From: Gregg, Robert <Robert.Gregg@lancashire.gov.uk>
Sent: 23 August 2018 09:49
To: Adam Birkett
Cc: planning
Subject: APP. 3/2018/0643 - 10 KNOWSLEY ROAD, WILPSHIRE

The proposal for the conversion along with an extension to the former care home to create 4 dwellings (3 x 3 bedrooms and 1 x 4 bedrooms)) The application form states that there are currently 4 parking spaces on site with the development proposing to provide a further 5 spaces to bring the total up to 9. Based on LCC's parking standards the proposed development would generate a requirement for 9 parking spaces which in this case would be sufficient.

PROPOSED SITE PLAN

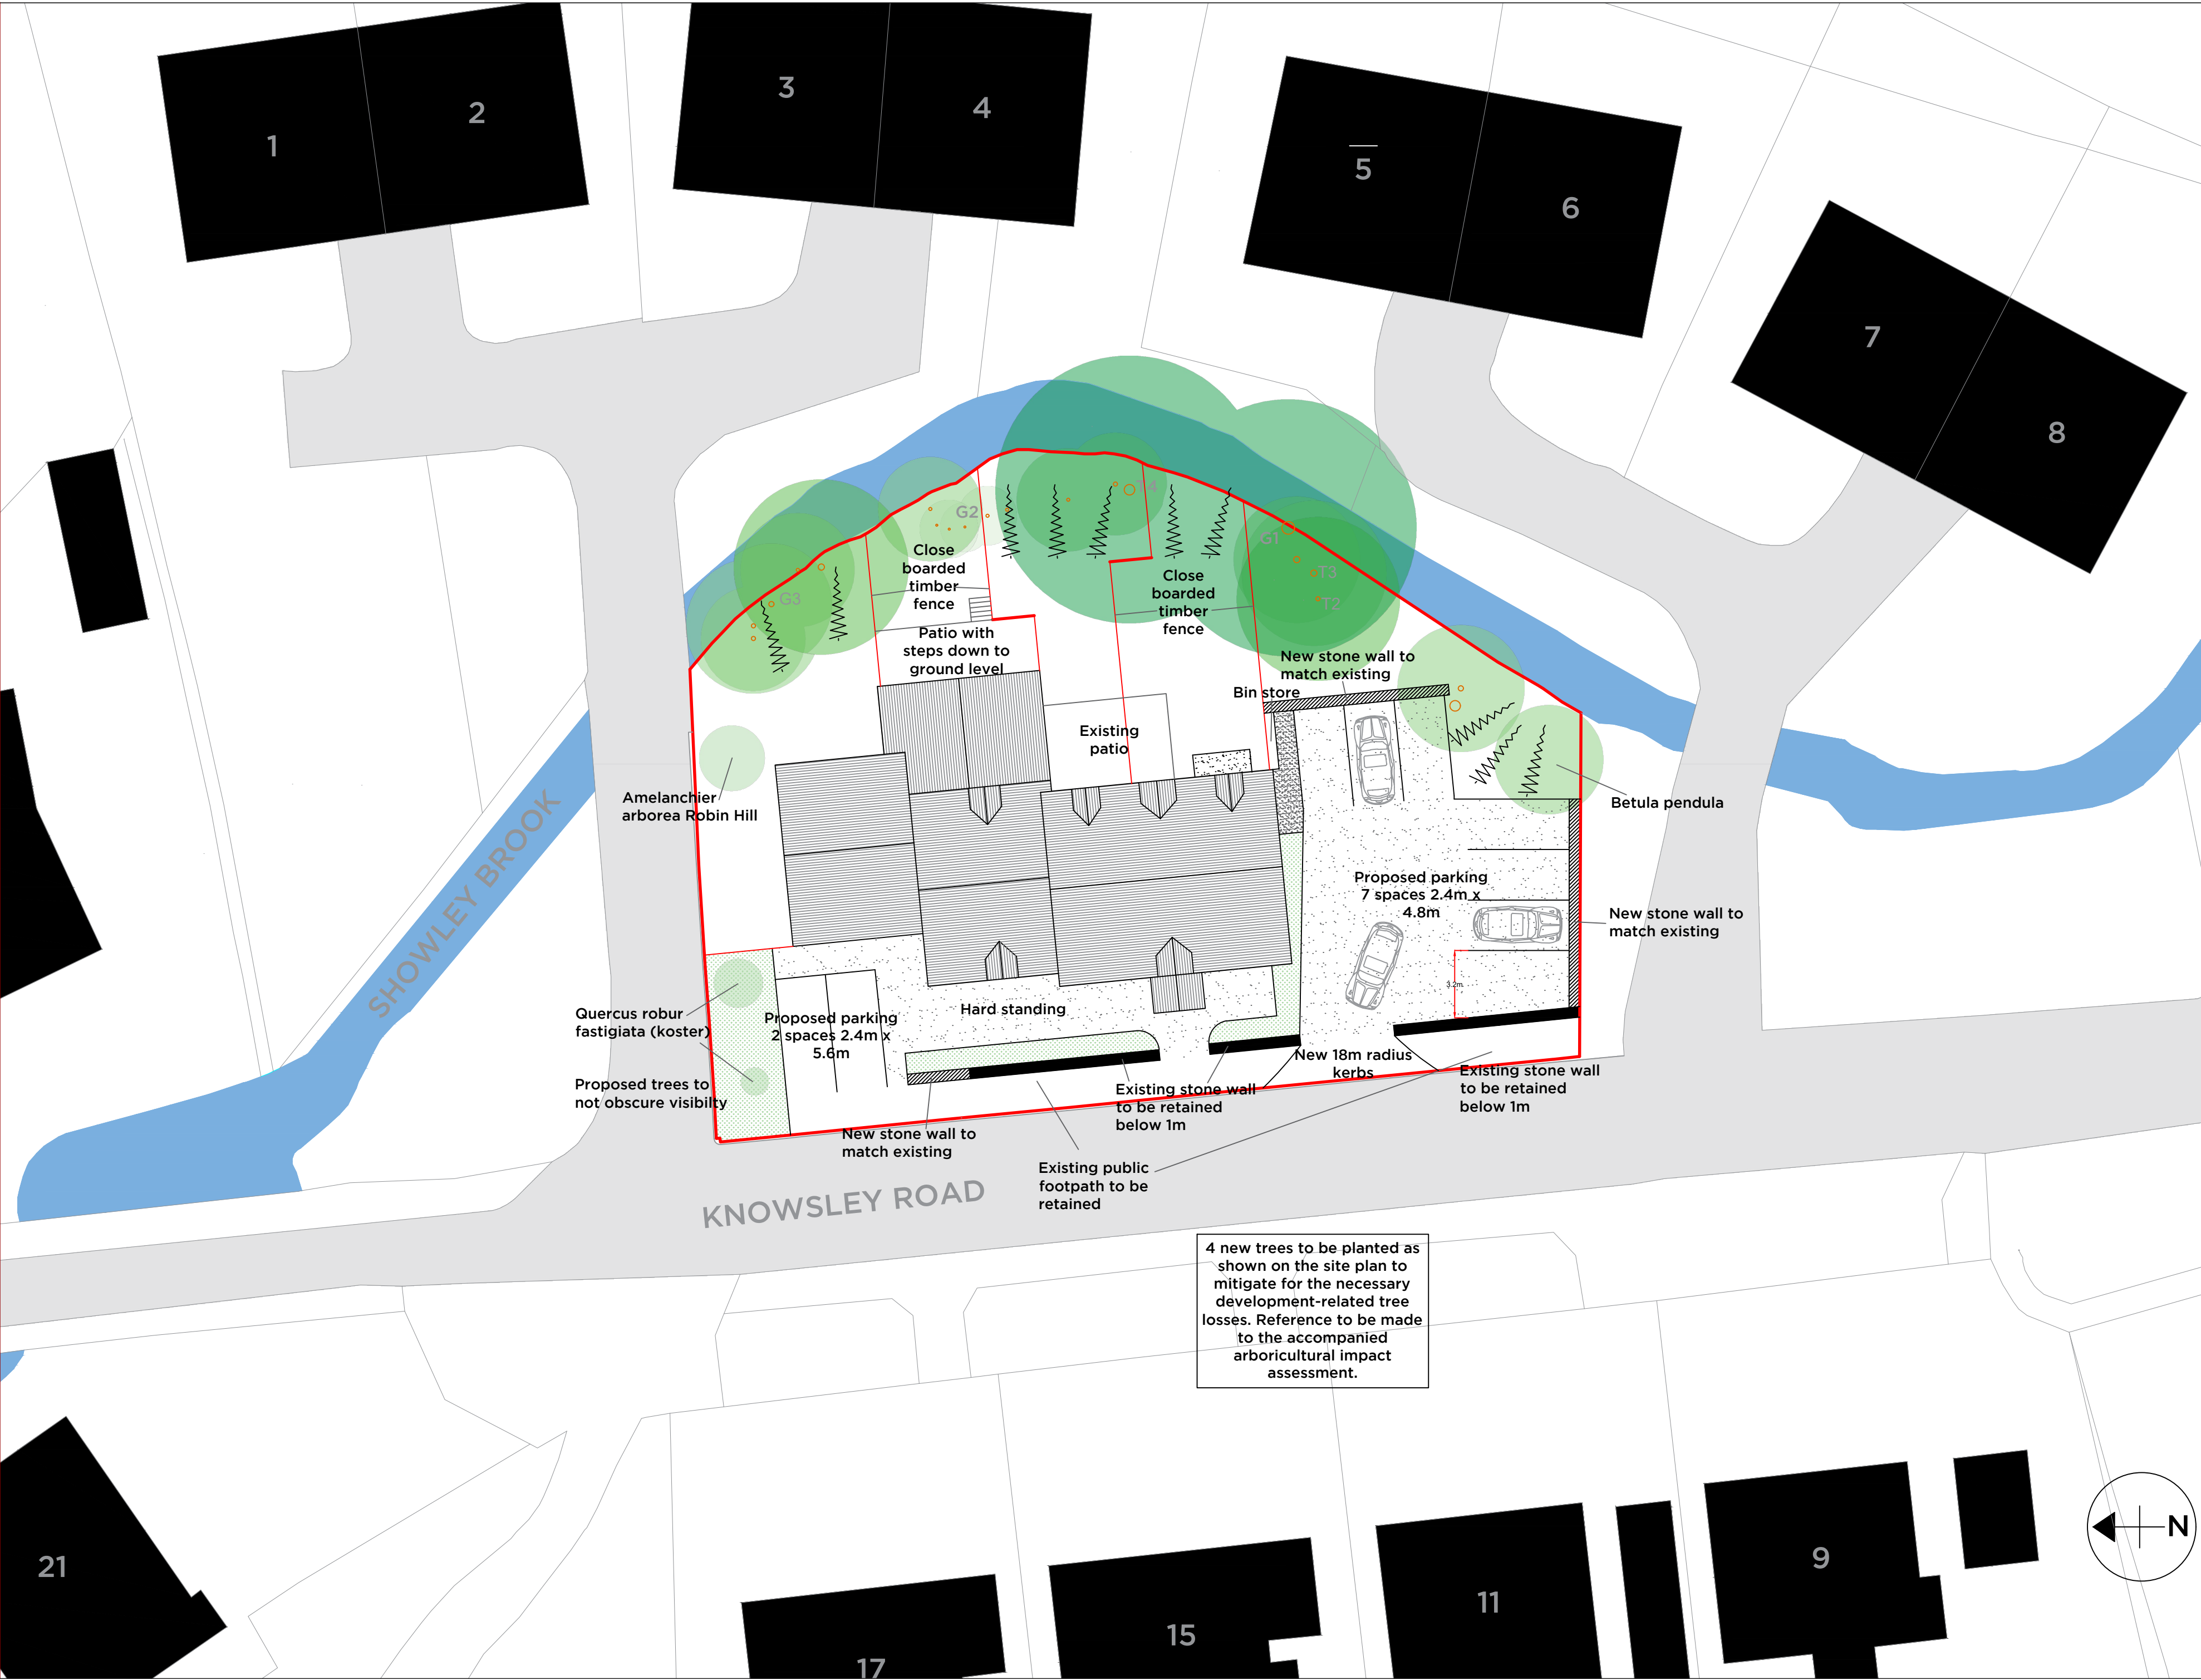
The submitted plans indicate that the proposed parking areas boundary wall would encroach the adopted service verge being a 2m walkway and as a result I would ask that the plans be revised detailing that the proposed boundary wall be set back out of the adopted highway. I would also ask that the new stone wall (Boundary wall) adjacent to the pedestrian walkway does not exceed 1.05m high as this would conflict with the visibility splay.
